From: Claire Booth
Sent: 12 March 2012 15:34
To: Jane Tucker
Subject: FW: Observations on this application please - Kendal House, 24 Chatburn Road

From: Nugent, Martin [mailto:Martin.Nugent@lancashire.gov.uk]
Sent: 12 March 2012 15:16
To: Claire Booth
Subject: RE: Observations on this application please - Kendal House, 24 Chatburn Road

SITE PLAN SCALE 1:2500

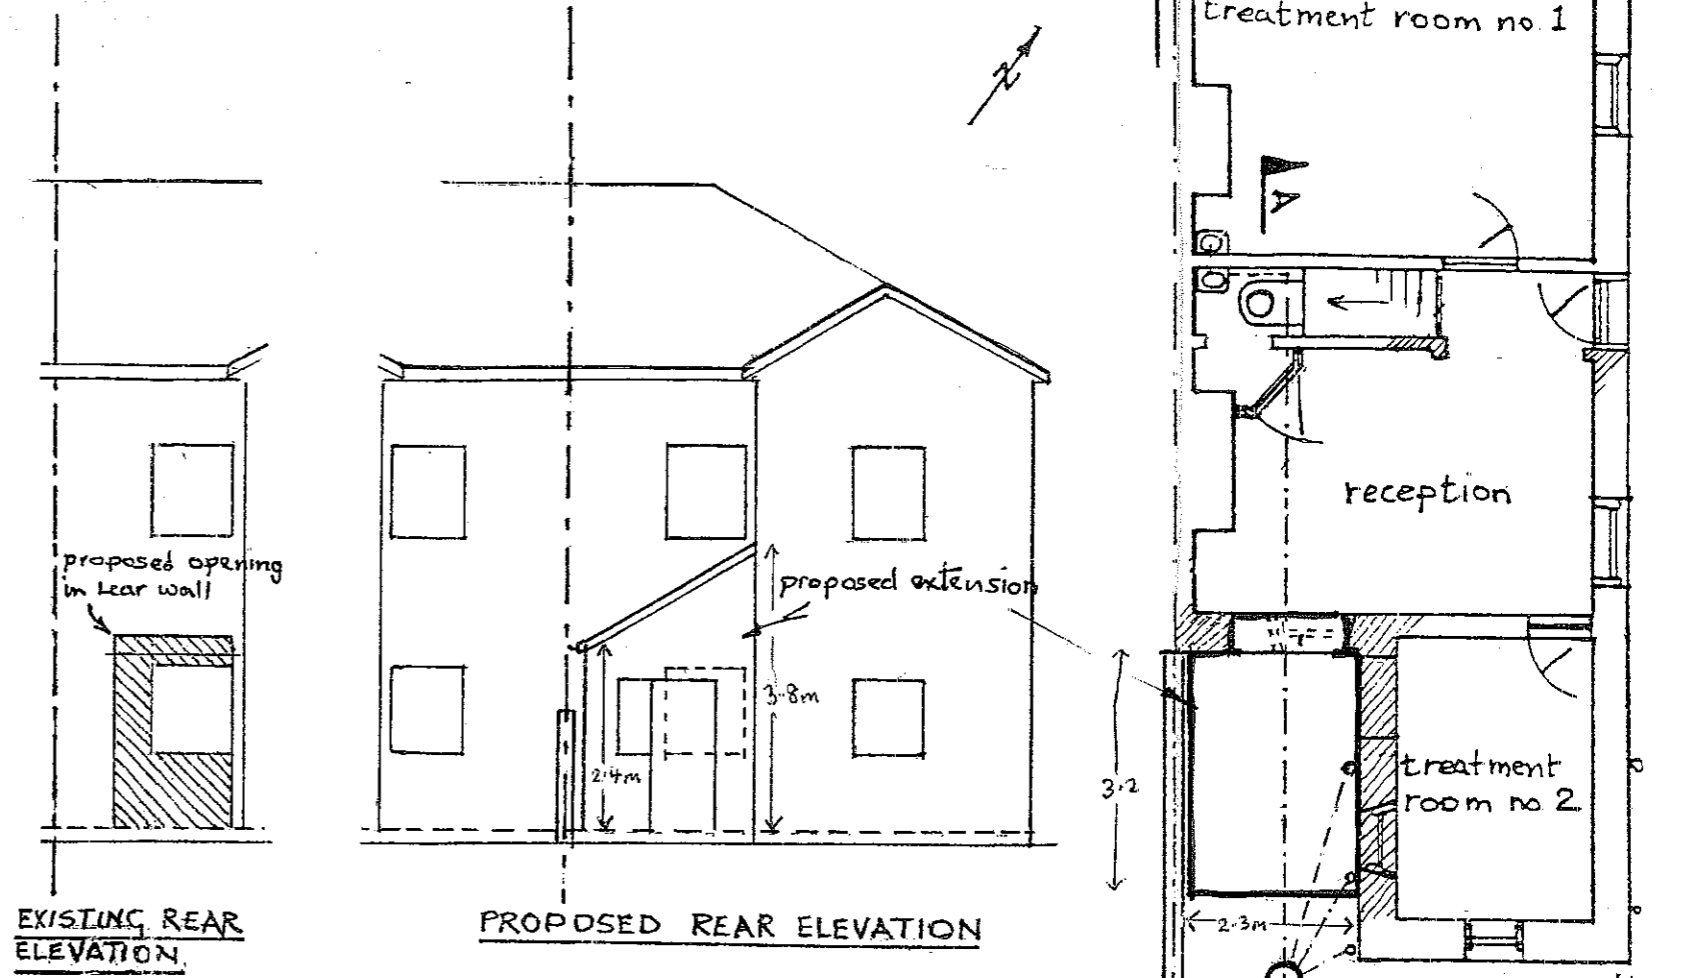
However, the applicant states that there are two of street car parking spaces to the rear of the property. These spaces are not presently identified on site and should be marked out permanently. Furthermore, if they are for the use of visitors/customers, what information is being provided by the practise to encourage the use of these spaces?
